Detailed Response to Submissions

Agency Submissions

Public Submissions

Hyde Park - Overshadowing Analysis | Annual Shadow Study

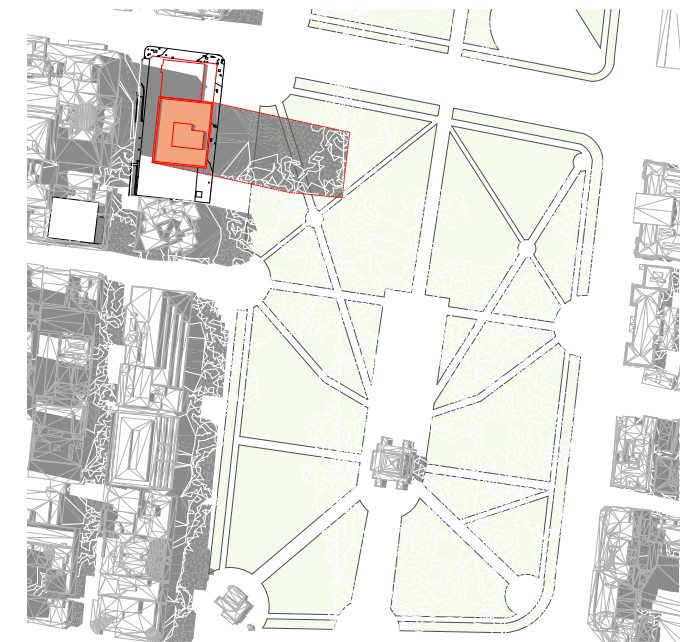
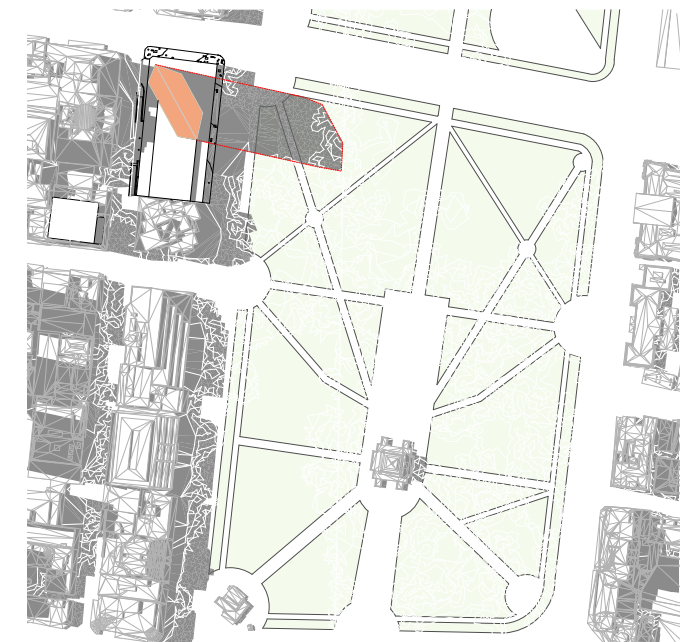
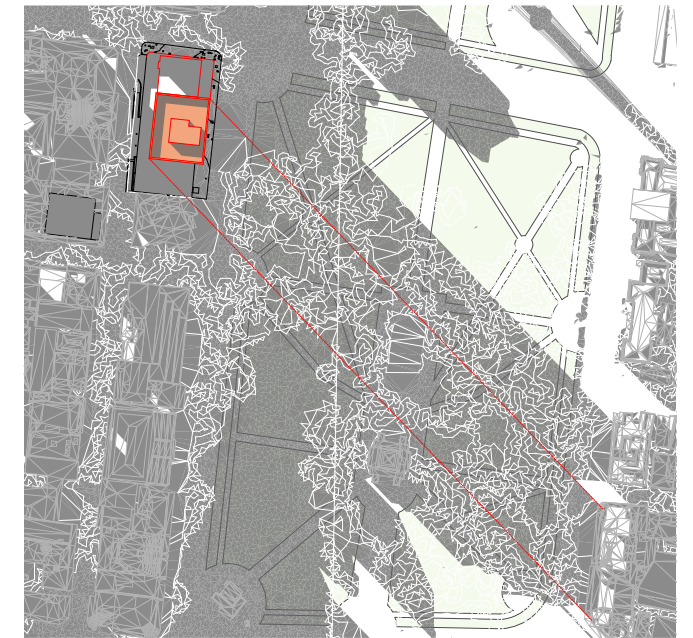
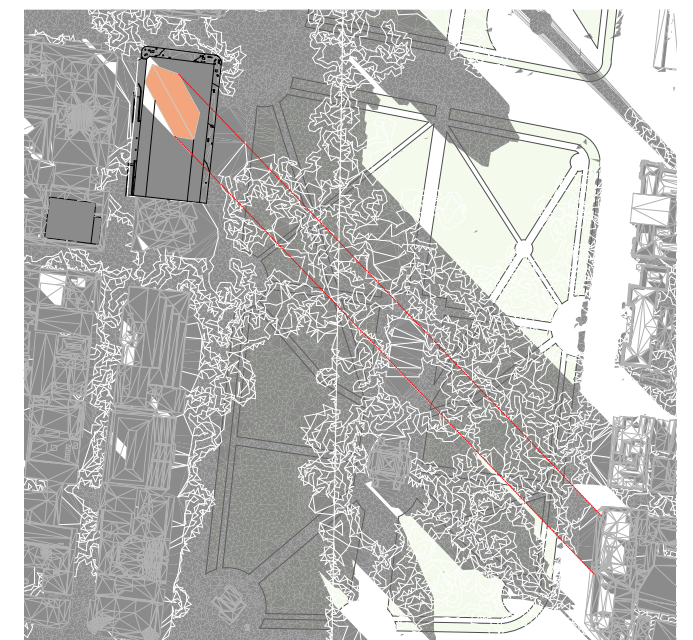
Number of times raised in submissions	Issue Raised	Comment/Design Response
41	Overshadowing The proposed development will cast additional shadow on Hyde Park. Shadow from the proposed development will impact on the Anzac Memorial. New buildings should not be permitted to cast additional shadow on Hyde Park and should improve sun access to the park.	The proposed building envelope will significantly reduce the shadow cast by the existing building on Hyde Park. Detailed shadow diagrams, including calculations of the 50% reduction on 21 June are provided at Appendix D and discussed further at Section 4.3 of the RTS.
71	Traffic The proposed development will cause increased congestion. The removal of the bus stop on Castlereagh Street will detrimentally effect residents of the area. The proximity of the car park and the porte cochere to the traffic lights will cause congestion. The proposed development is close to the Pitt Street North Metro Station and may impact construction. The proposed development will result in more vehicle cross over points along the Castlereagh Street footpath. The amount of car parking provided is excessive. Access to the basement of the neighbouring building will be compromised.	The RTS provides an amended ground floor plane to directly respond to submissions relating to site access (Refer to Section 3.4 and Appendix C of the RTS). This amended ground floor plane will improve the amenity and activation of Castlereagh Street. The Transport Study (Appendix E) demonstrates that the traffic generated by the proposed development will have a negligible impact on the existing road network given the CBD context. The proposed car parking accords with the maximum car parking rates established in the SLEP 2012.
